Reference No:	2026/62/91559/W
Site Address:	Castle View House, New Mill Road, Wooldale, Holmfirth, HD9 7LT
Description:	Raising rear decking by up to 1050mm, new bi-fold doors to master bedroom. repointing stonework and quoins, installing metal and glass balustrade to rear of decking, replacement of all external windows and doors, replacement of existing sliding electric entrance gate and installing 600mm high metal railing to boundary wall
Recommending Officer:	Joshua Merriman

Officer Report – 2026/91559

PROPOSED ELEVATIONS

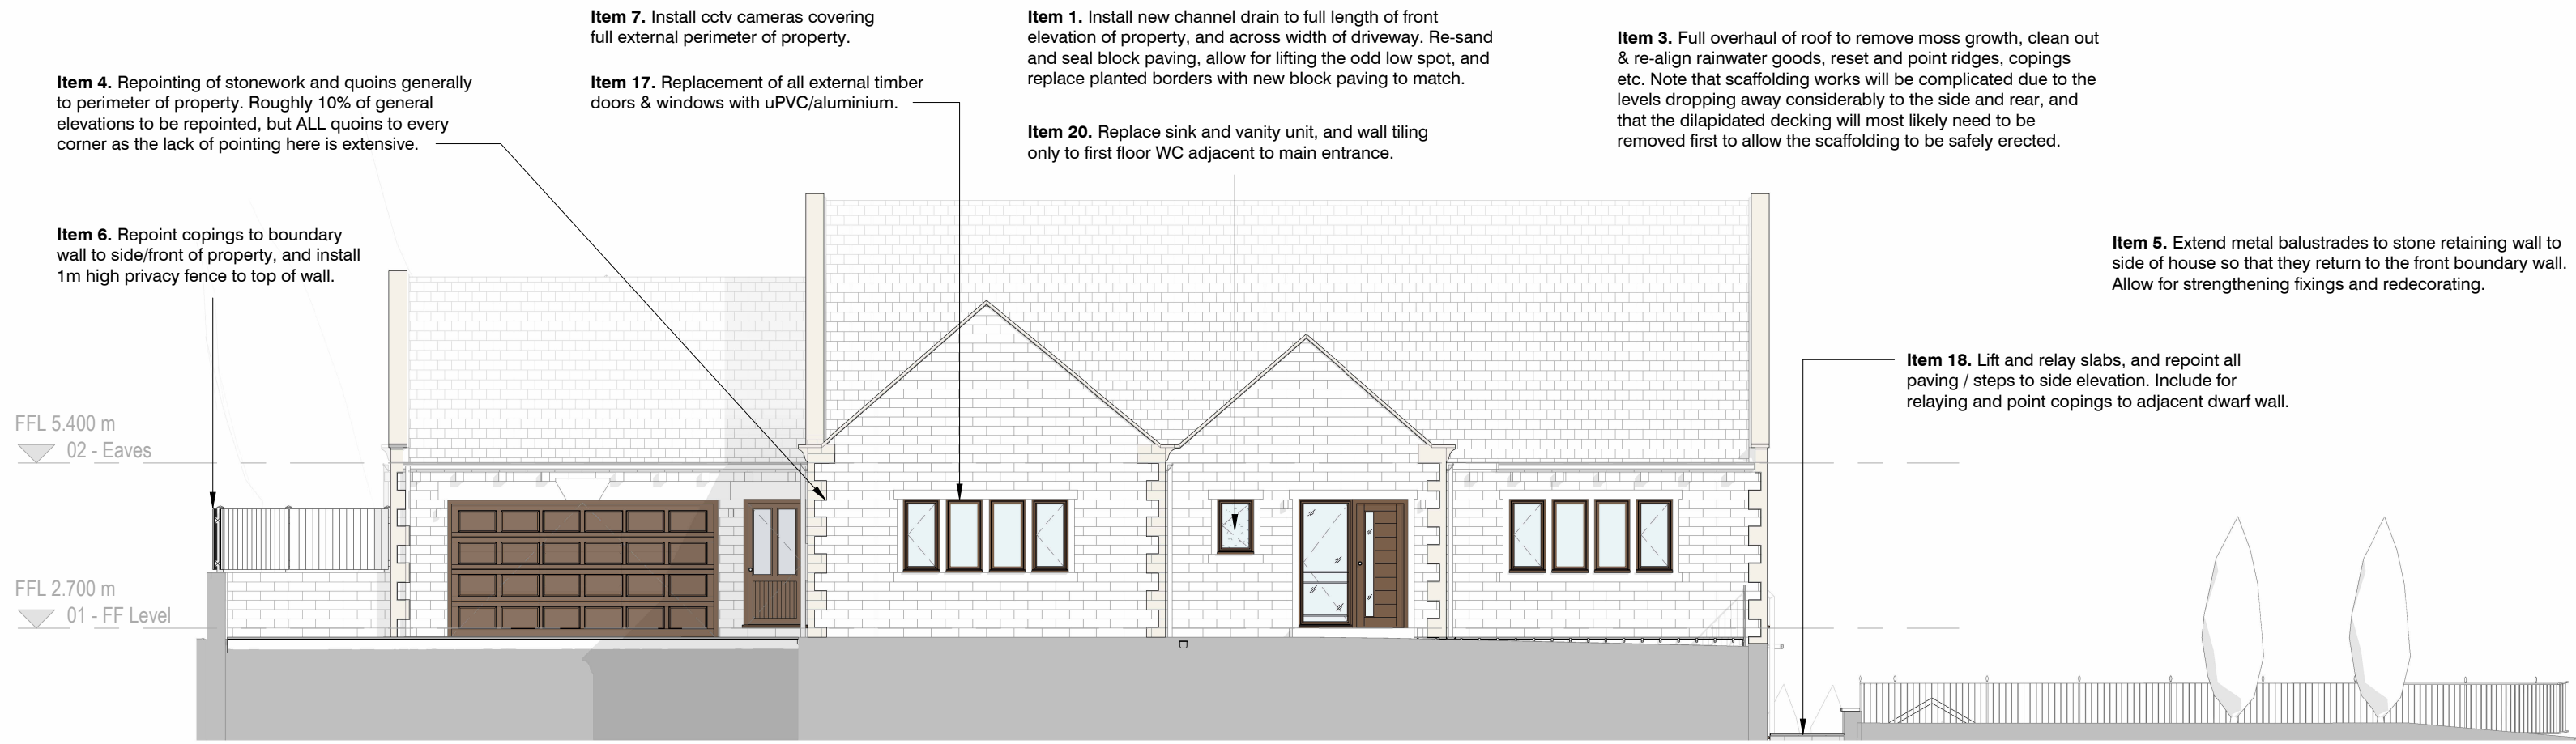
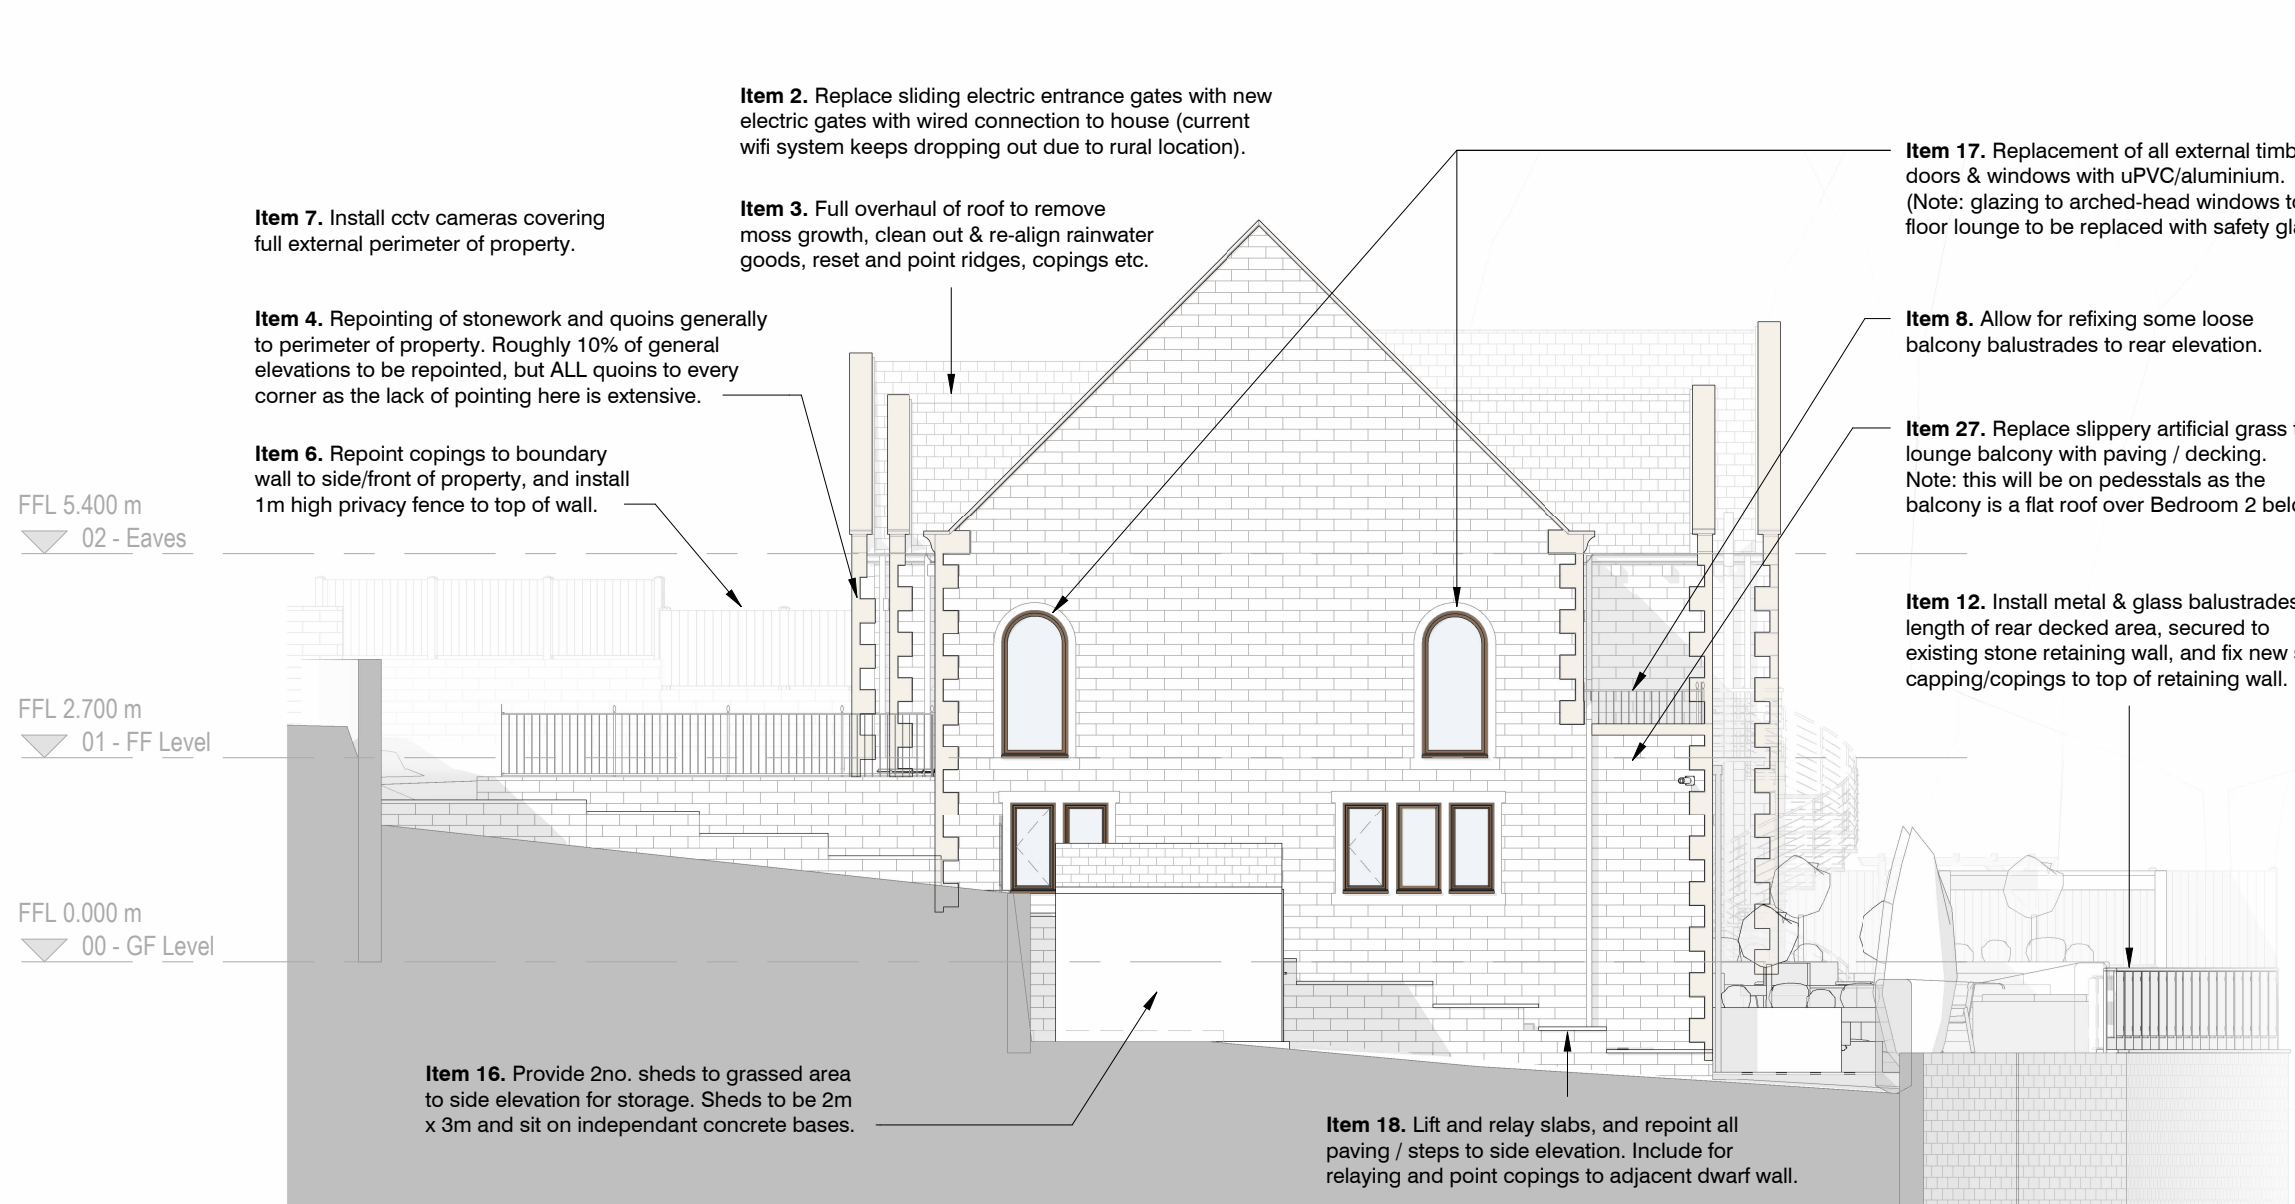
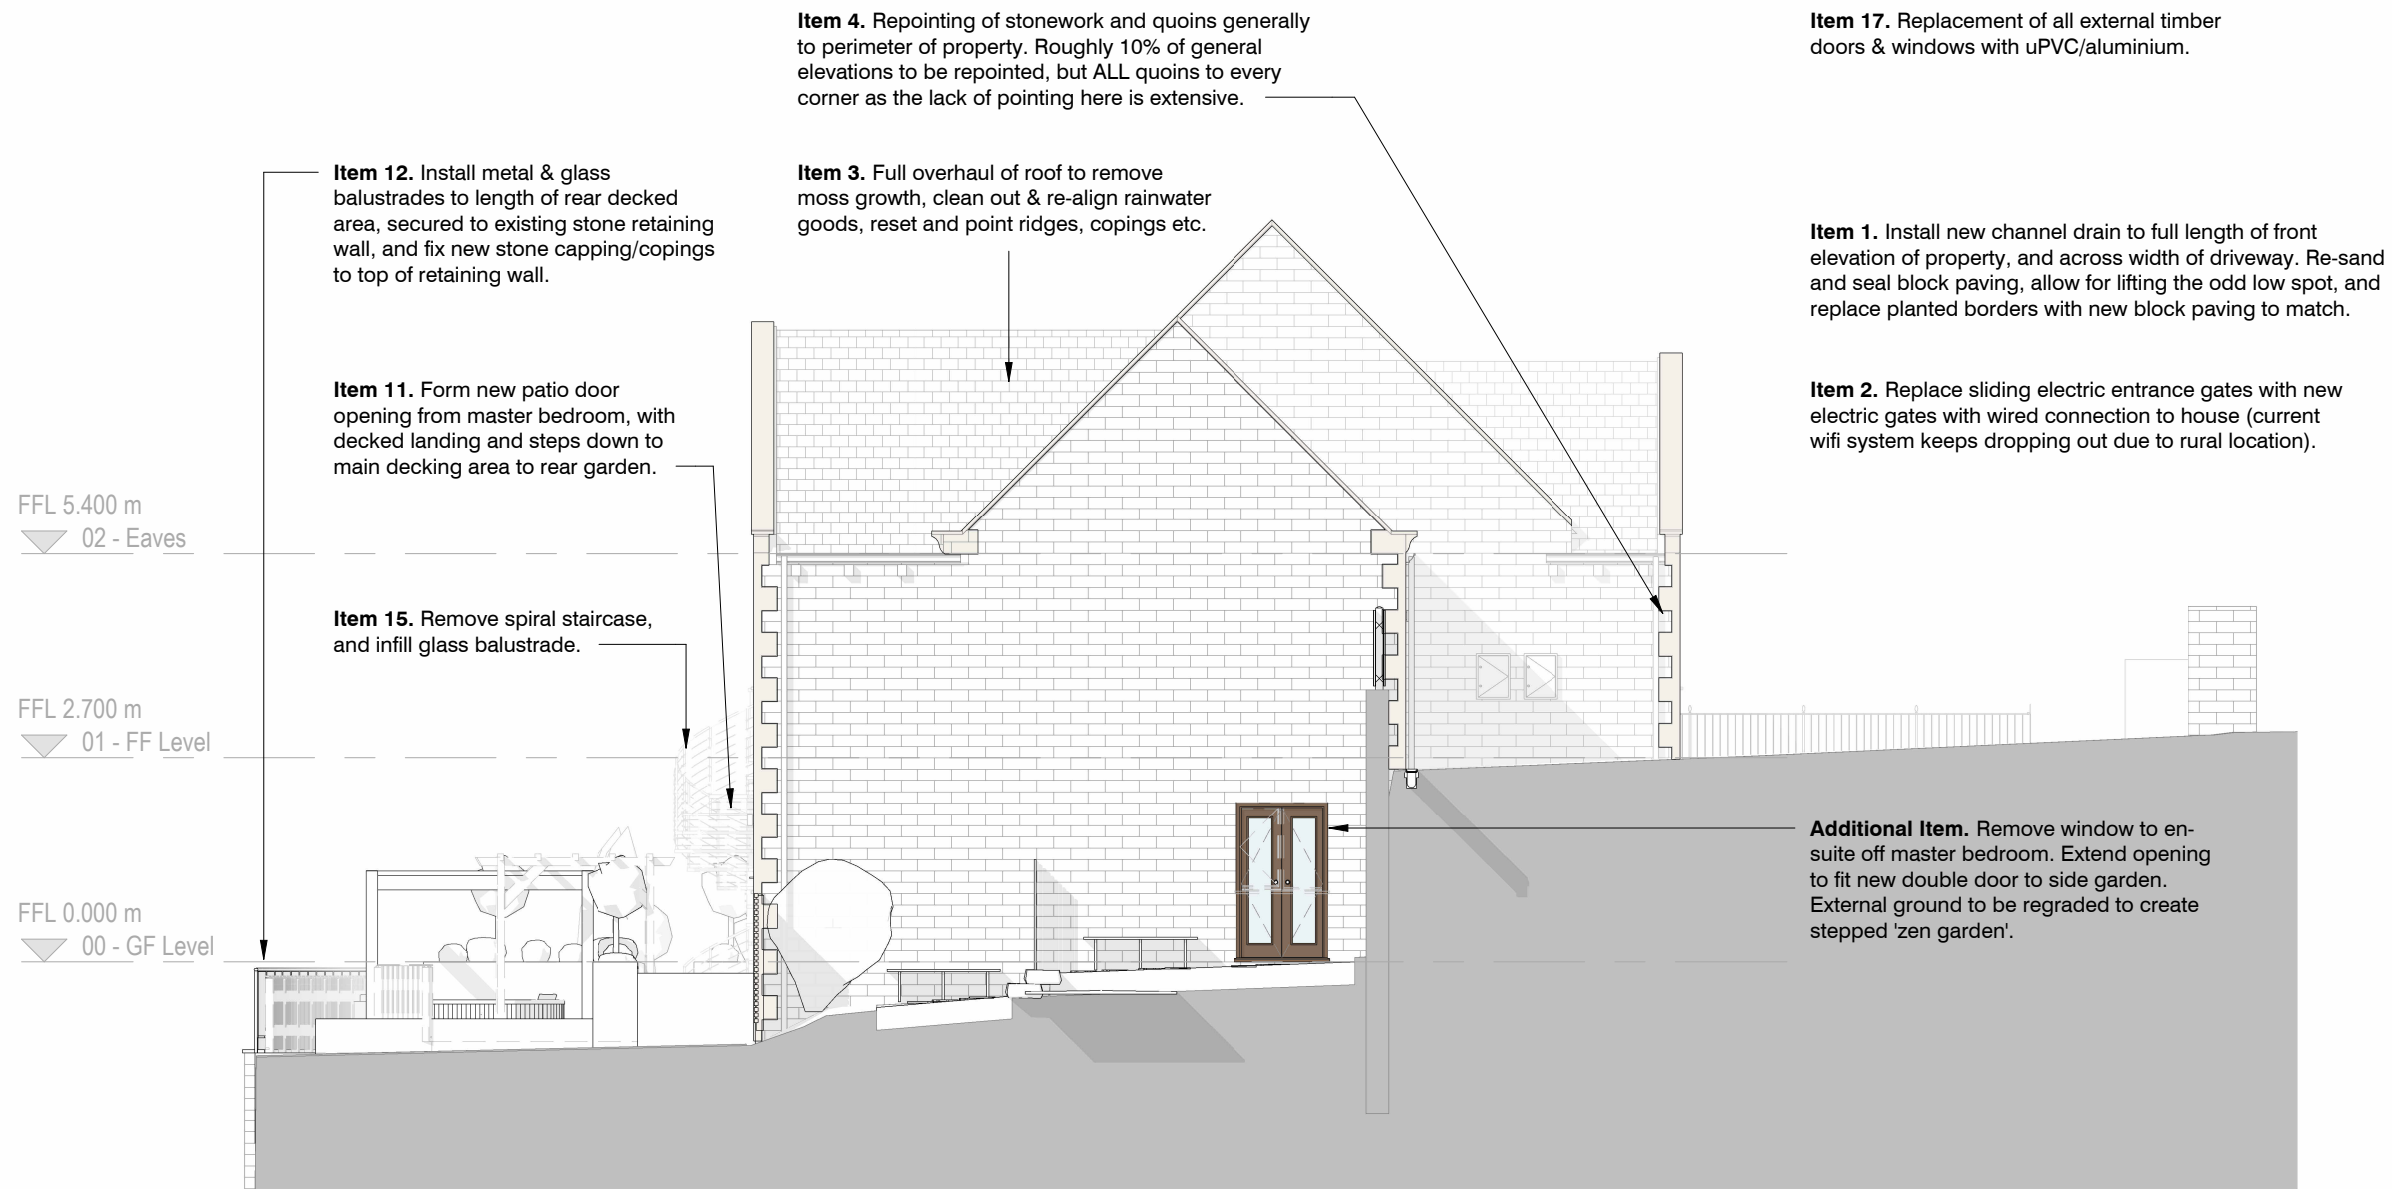
As the raised rear decking, bi-fold doors to master bedroom, and metal and glass balustrades will be located to the rear of the property and not visible from the street scene, it is considered that these aspects of the development will have no significant impact upon the visual amenity of the host property or surrounding area.

The raised rear decking, bi-fold doors to master bedroom, and metal and glass balustrades will face West, onto a heavily natural screened area dropping significantly in slope, therefore, no significant overlooking potential or privacy impacts are considered to be derived from these alterations as they would not significantly alter the overlooking potential that is currently existing from the rear of the property.
